## **OXFORDSHIRE COUNTY COUNCIL'S RESPONSE TO CONSULTATION ON THE FOLLOWING DEVELOPMENT PROPOSAL**

**Application no:** 22/00907/REM

**Proposal:** Reserved matters application to 19/01740/HYBRID - Layout, scale, appearance and landscaping details for Phase 2 of the employment development (11,310sqm GIA) with associated landscaping, utilities and access.

**Location:** Land Adj To Promised Land Farm, Wendlebury Road, Chesterton

Drawing Title.  
**UNIT 6  
FLOOR PLANS**

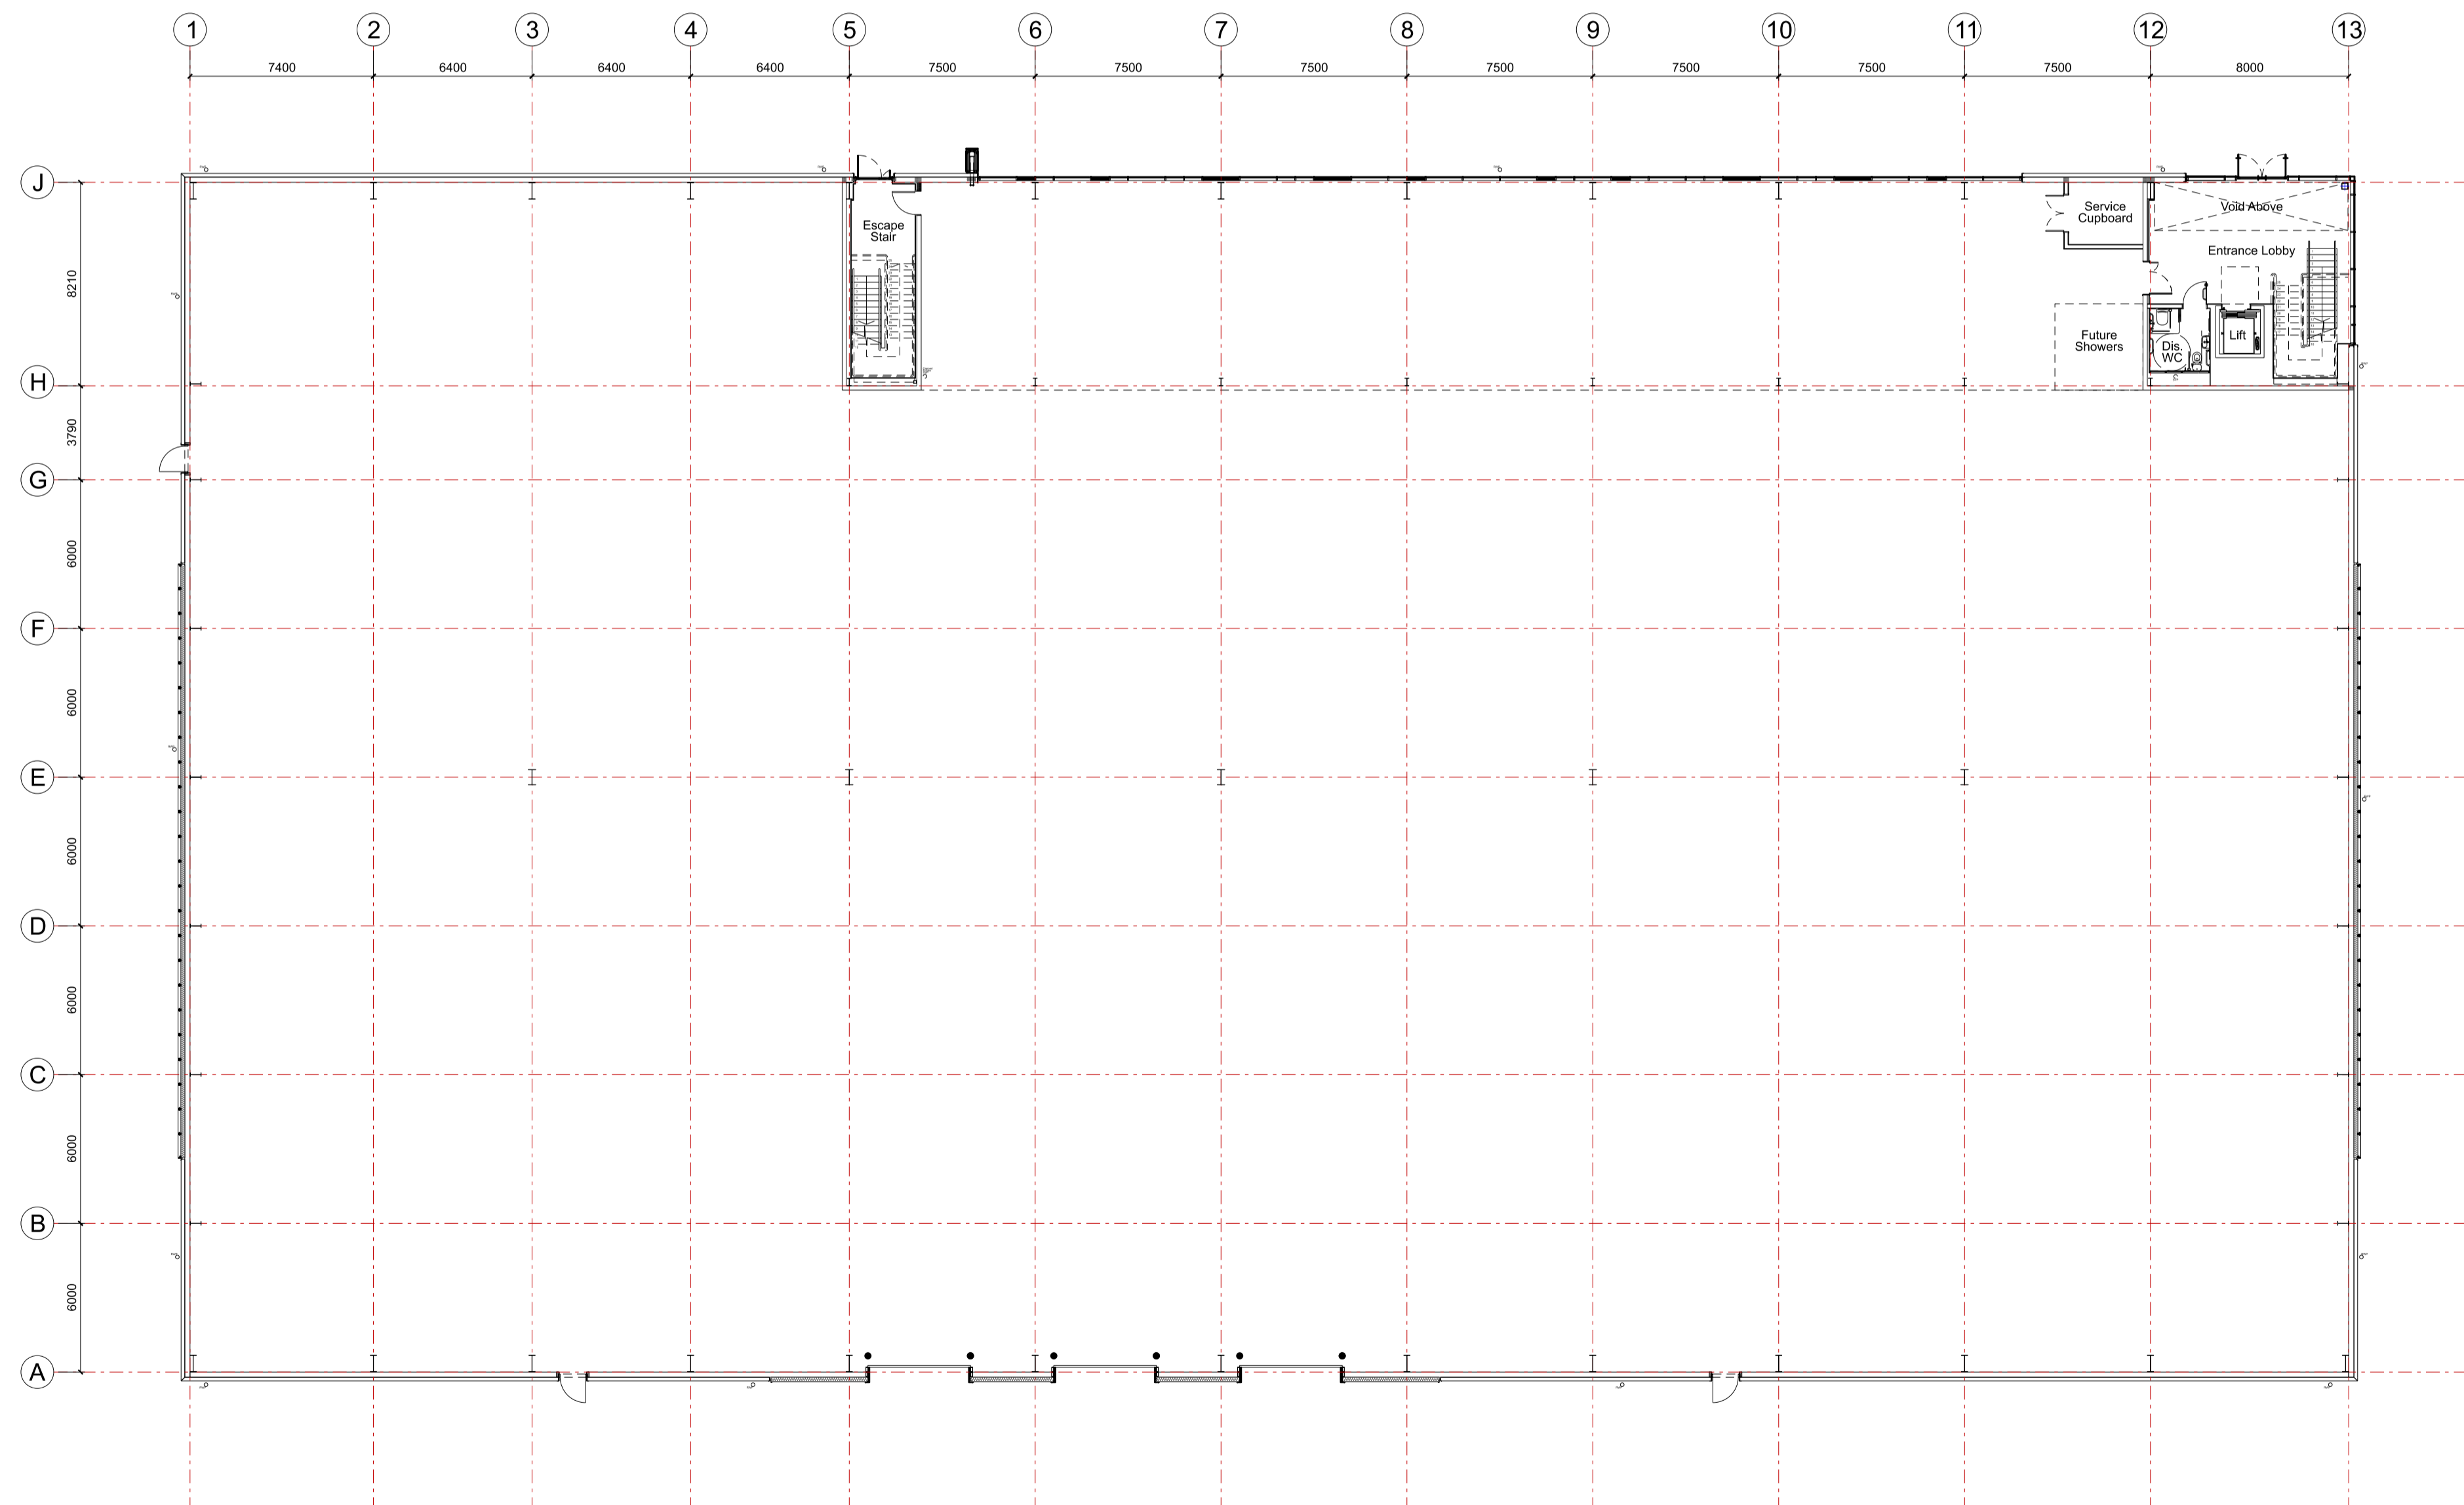
Poor routes into unit 6 – a path needs to be provided around the point of the dropped kerb south of the mini roundabout and into the site. Unofficial paths will become worn over desire lines if paths are not provided. Paths should be as direct as possible to reduce walking distances and therefore encourage sustainable travel to the site.

Prior to commencement of the development hereby approved, details of a direct walking provision/link onto Unit 6, including path widths, shall be submitted and approved in writing by the Local Planning Authority. Thereafter and prior to the occupation of each unit, the walking route to it shall be completed in accordance with the approved details.

Drawing Title: **CYCLE SHELTER DETAILS**

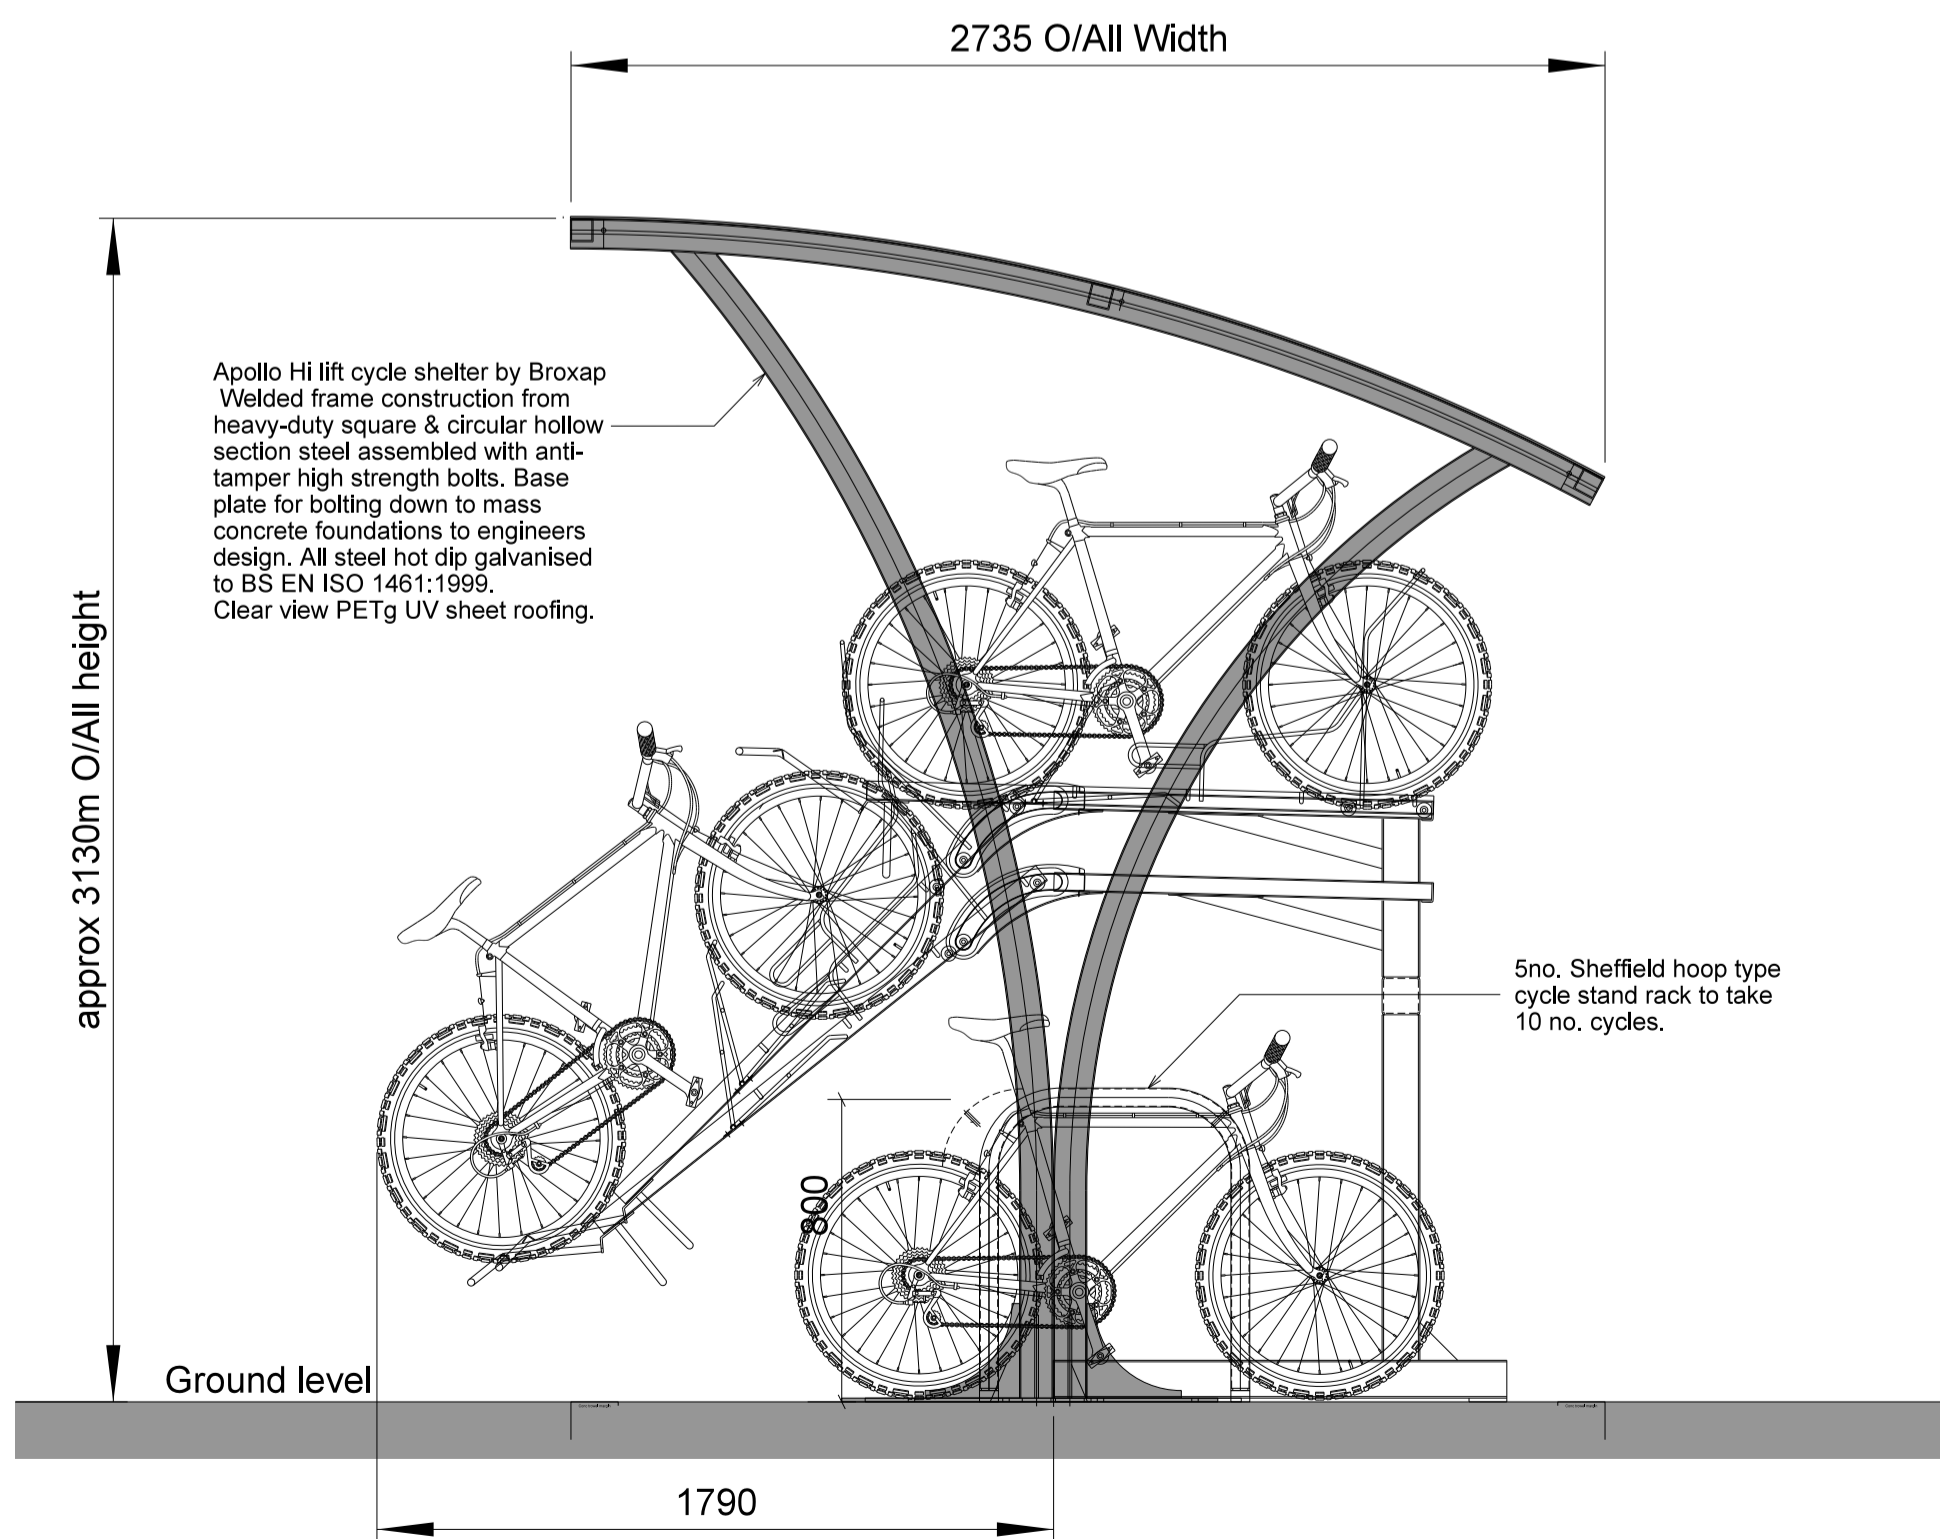
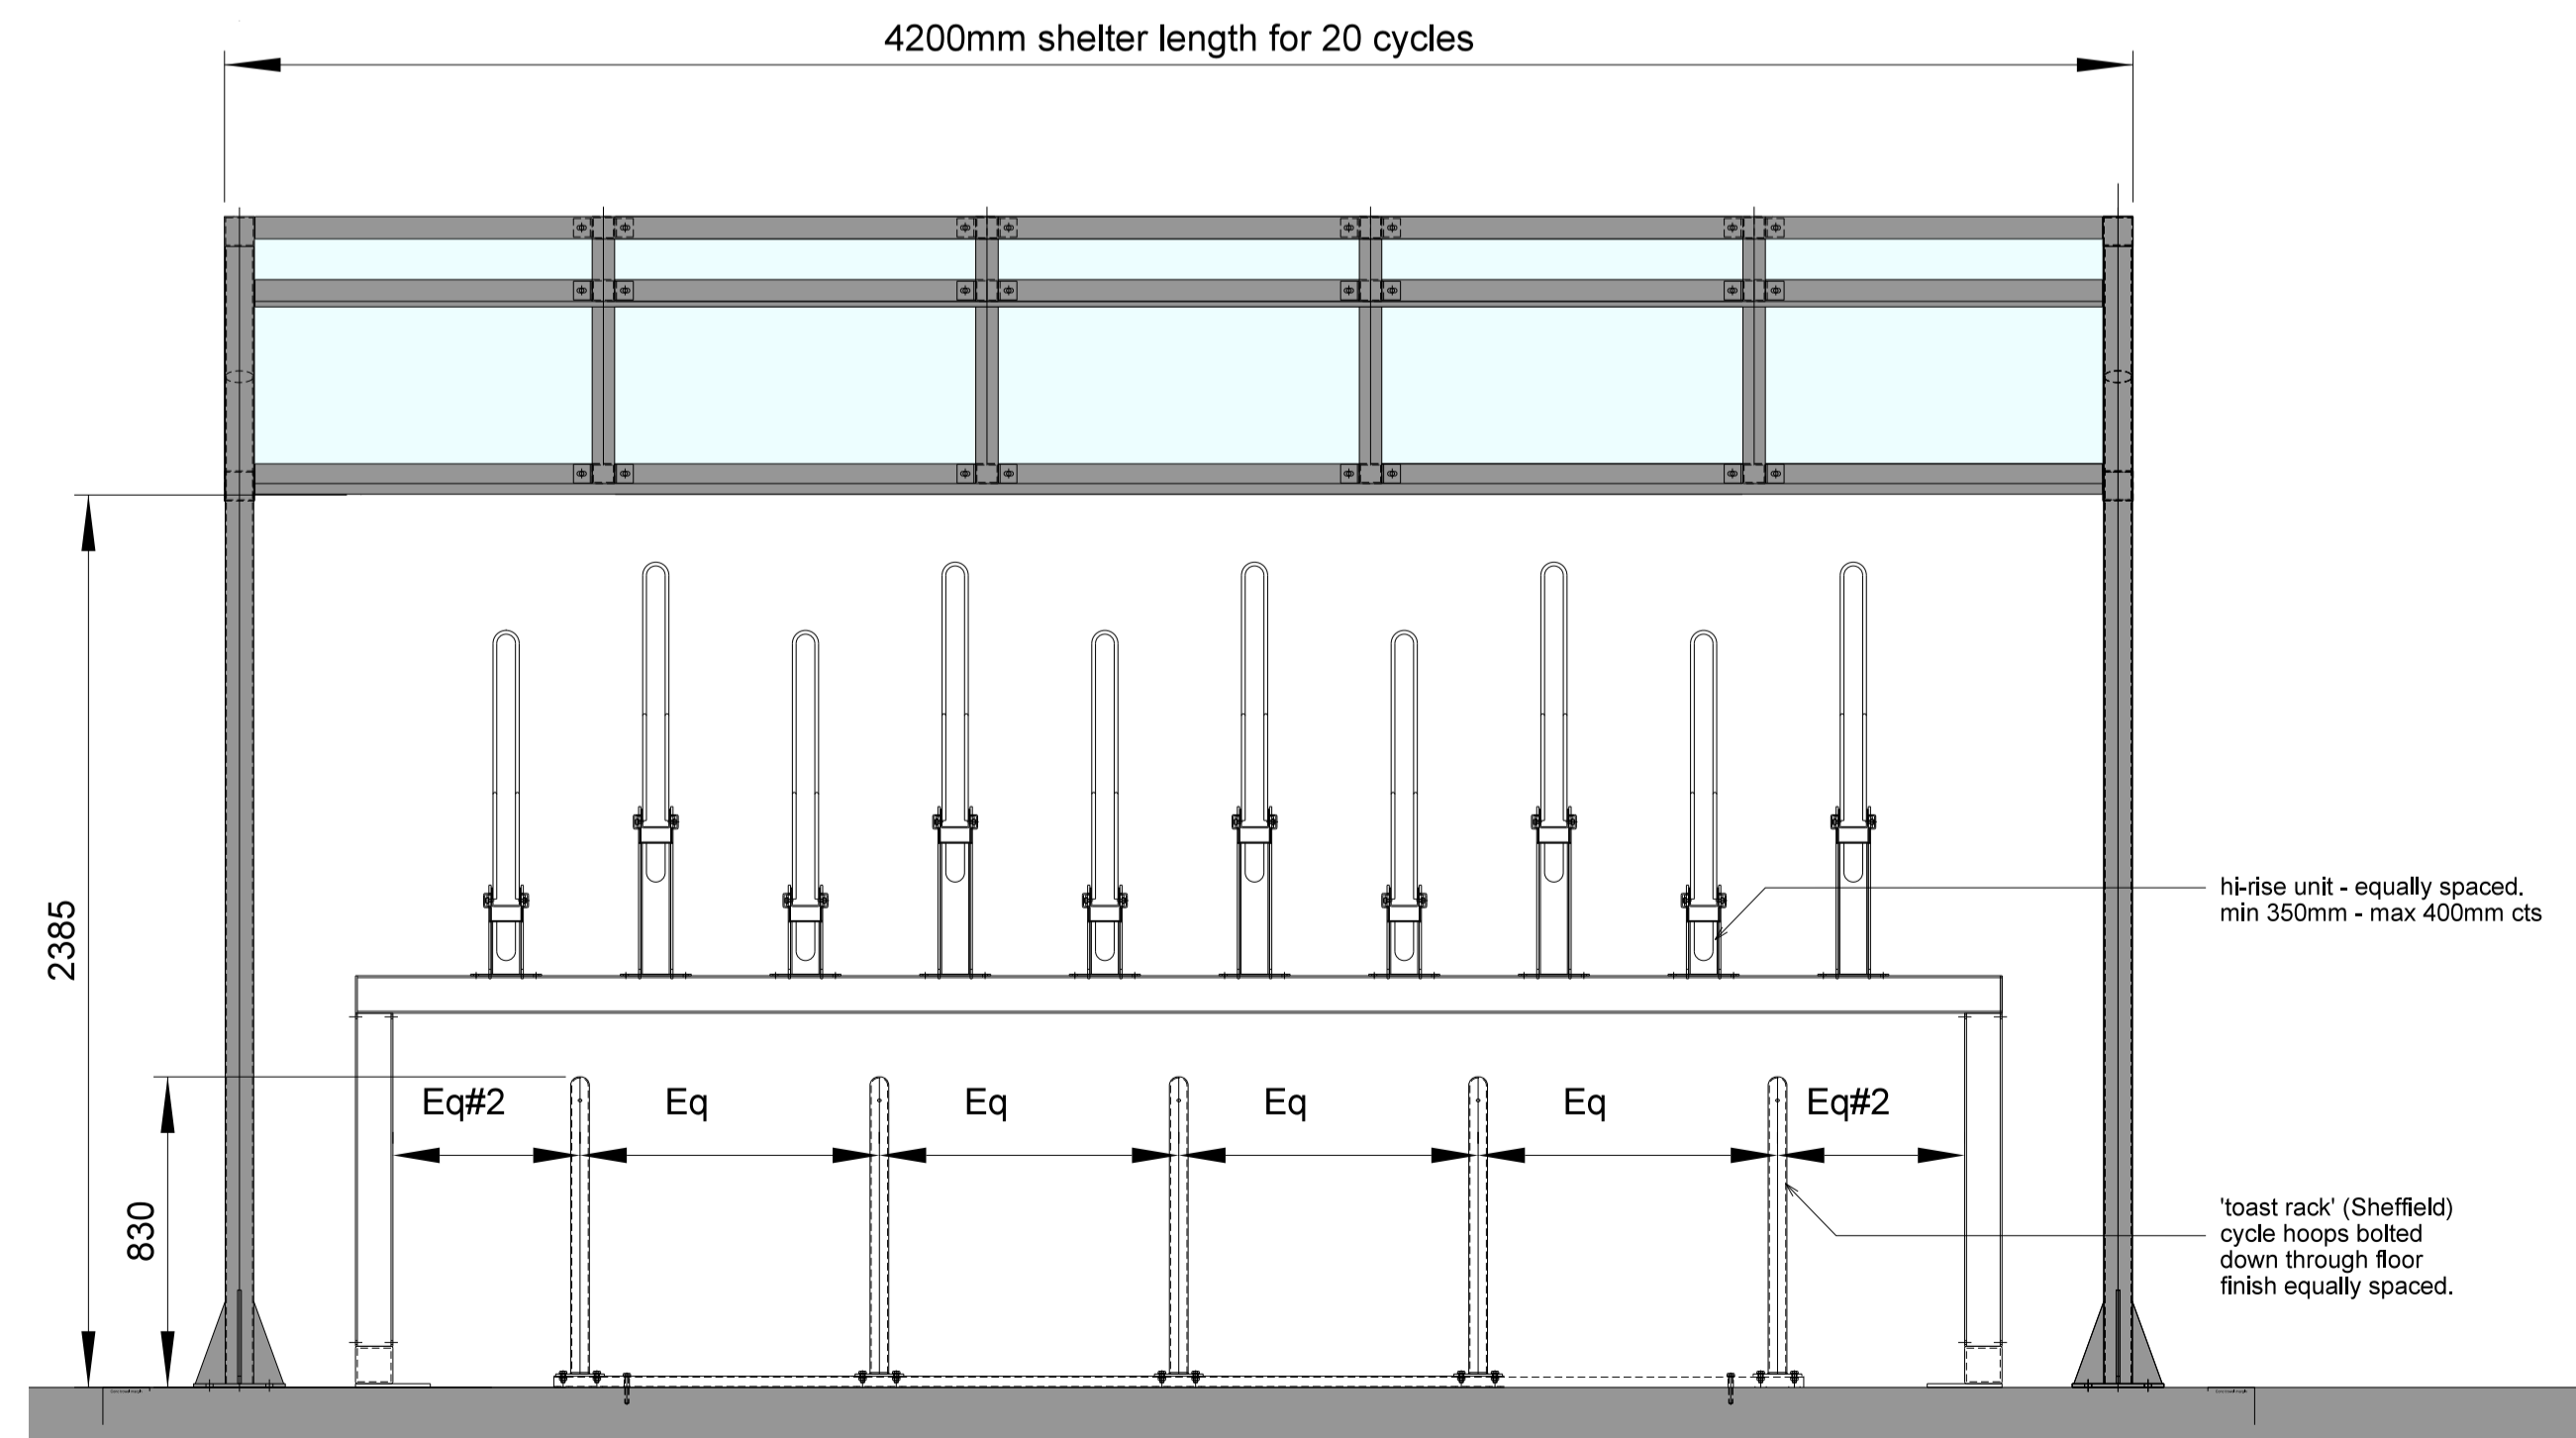
*Cycle Parking* - The overall number of proposed cycle spaces is acceptable. It appears that all the cycle parking facilities proposed are covered double deck parking, which requires considerable space in front to allow cyclists to use the mechanism to place and remove bikes from the upper deck. Particularly in unit 6 they do not appear to be adequately spaced. Placing rows of decked cycle parking with an aisle between them could also make it difficult to operate when several users arrive at once at the beginning

or end of shift. I would like to see more details of this arrangement to ensure it can be conveniently used.

Additionally for units 5a and 5b, the double deck parking appears to be close to a kerb, which could present difficulties for users. The rack needs a flush surface in front of it for loading/unloading cycles.
